Our Ref:CC190015

ALDI Prestons - (Response to RFI - Aldi Distribution Centre 05_0142 MOD 2)

The response has been prepared to address an RFI from the NSW Department of Planning, Industry and Environment dated 06/08/2019.

TITLE:	LANDSCAPE PLAN-1	DWG.No:	LPDA 19 - 195 / 1
SCALE:	1:200 @ A3	DATE:	JUNE 2019
PROJECT:	PROPOSED COMMERCIAL CAR PARKING DEVELOPMENT	DRAWN:	K.Z
LOCATION:	BURANDO ROAD PRESTONS	CHECKED:	R.F

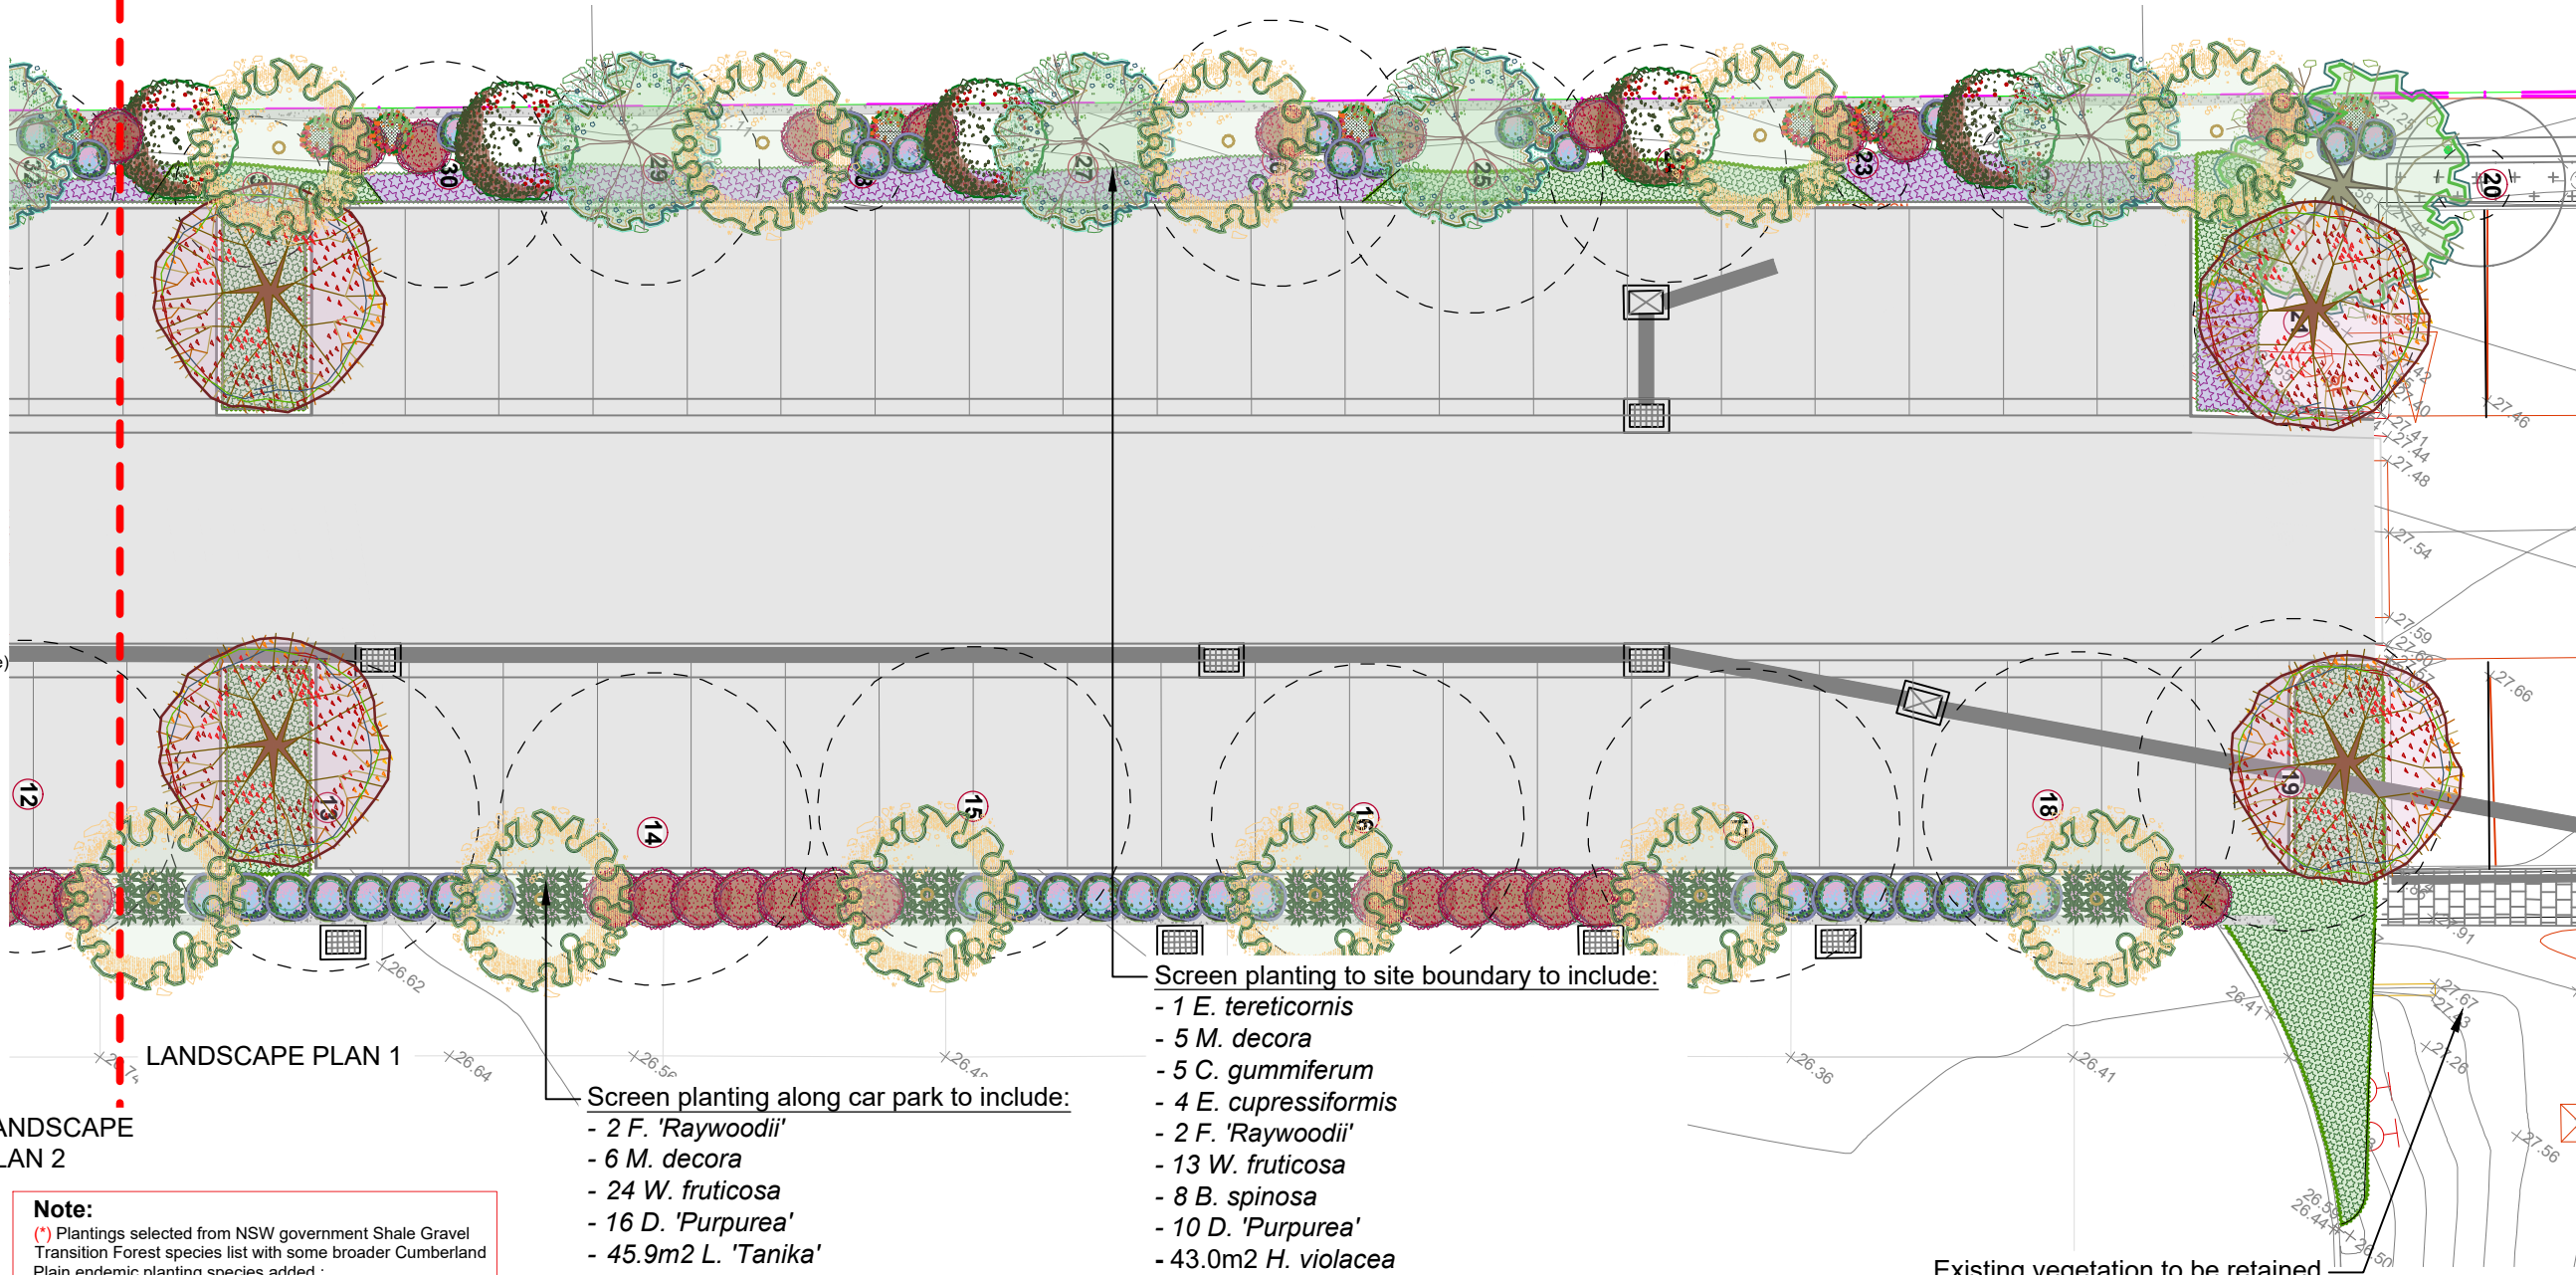
The Landscape Plan has been amended to address the issues raised in the referral comments.

Local native species will be integrated within the site to retain the existing tree canopy and to align with the character of the Shale-Gravel Transition Forest ecological community. Chinese Tallow Tree has been removed from the Landscape Plan and replaced with Claret Ash. The remainder of planting proposed will incorporate a variety of Sandstone Gravel Transition Forest Vegetation and Endemic Cumberland Plain Species as per DPIE request.

The revised Landscape Plan proposes to replace the removal of 51 trees with 62 trees, thus achieving a replanting ratio greater than 1:1. This replacement of removed trees is proposed to reduce any impact on the biodiversity of the site.
